Our Ref: BE/127/12/A
Your Ref:

Town & Country Planning (Control of Advertisement) (England) Regulations 2007 (as amended)
Application for Consent to Display an Advertisement(s)

Development Various non-illuminated & internally illuminated signage

Location Former LEC Site Shripney Way Bognor Regis

CHQ.12.9691-PL14 A

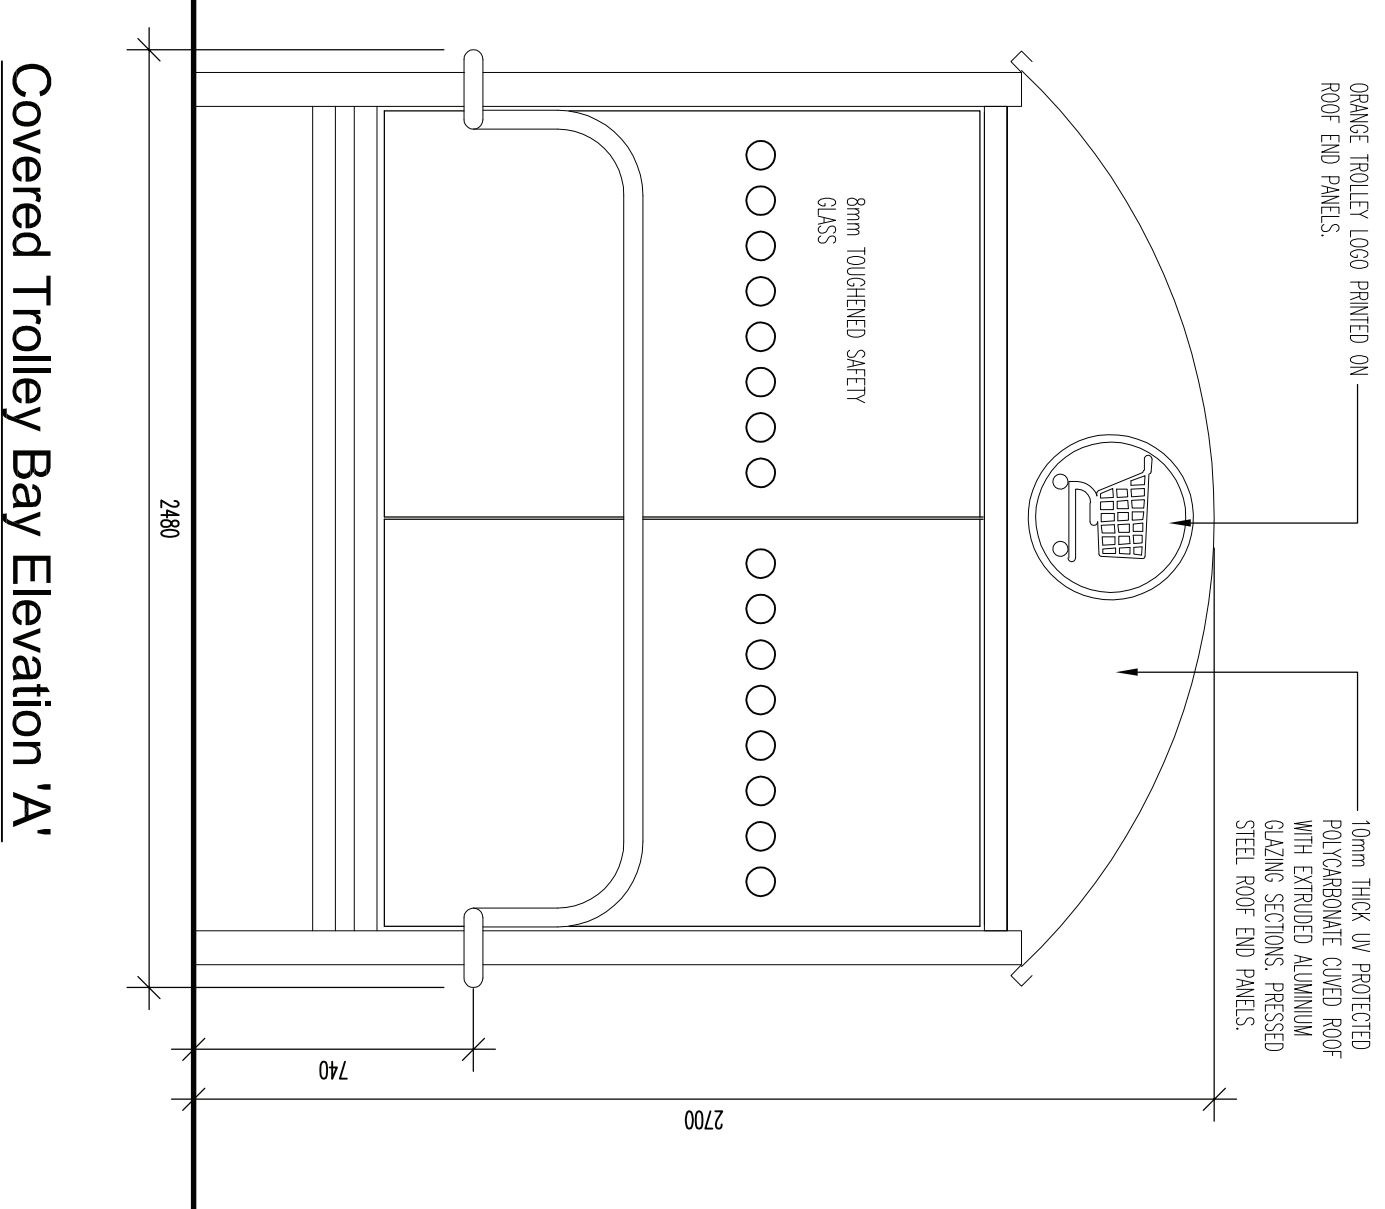
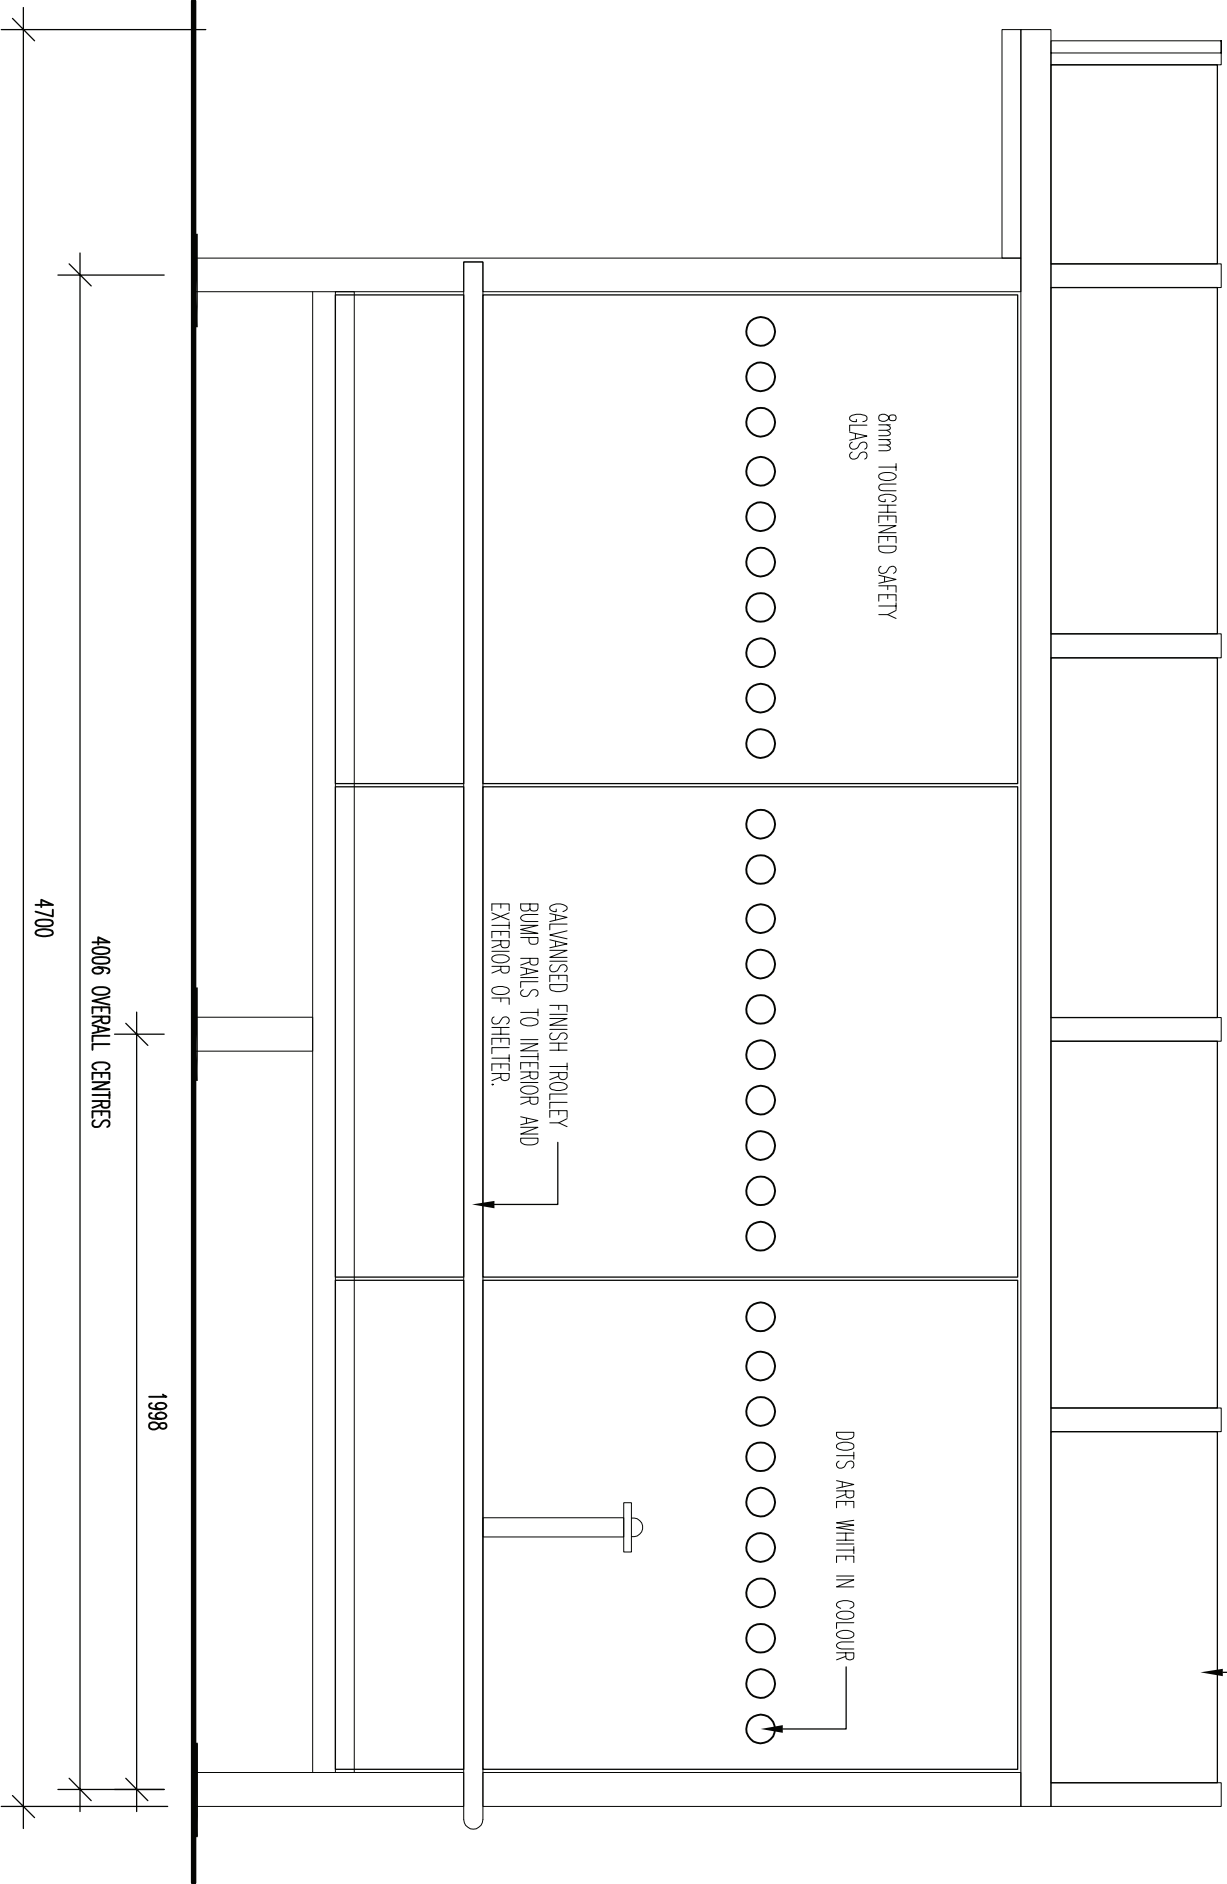
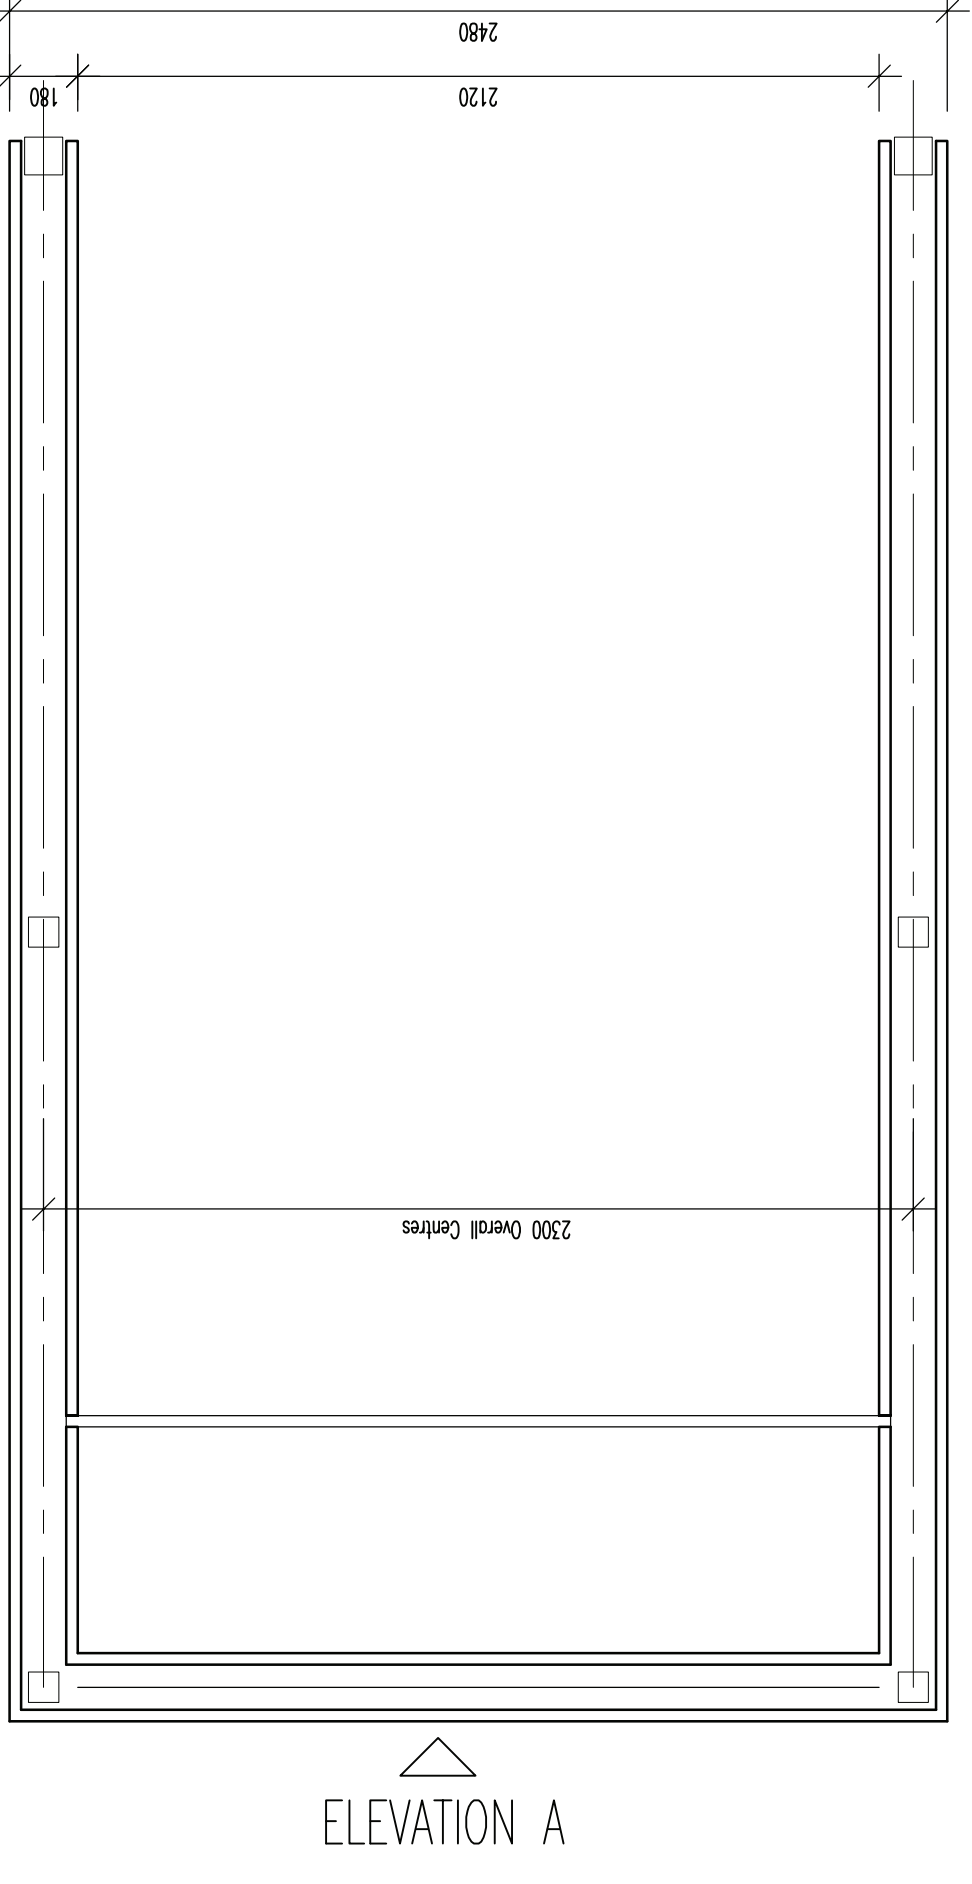
- The red edge on the proposed site plans: CHQ.12.9691-PL11 and CHQ.12.9691-PL12 must match the location plan 2486/200 Rev A. Please amend.
- Plan no. CHQ.12.9691-PL14 shows 11 trolley bays, however the schedule states there are 24 trolley bay logos (2 per bay) which would suggest that there should be 12 trolley bays. Please amend the schedule/plan as applicable.
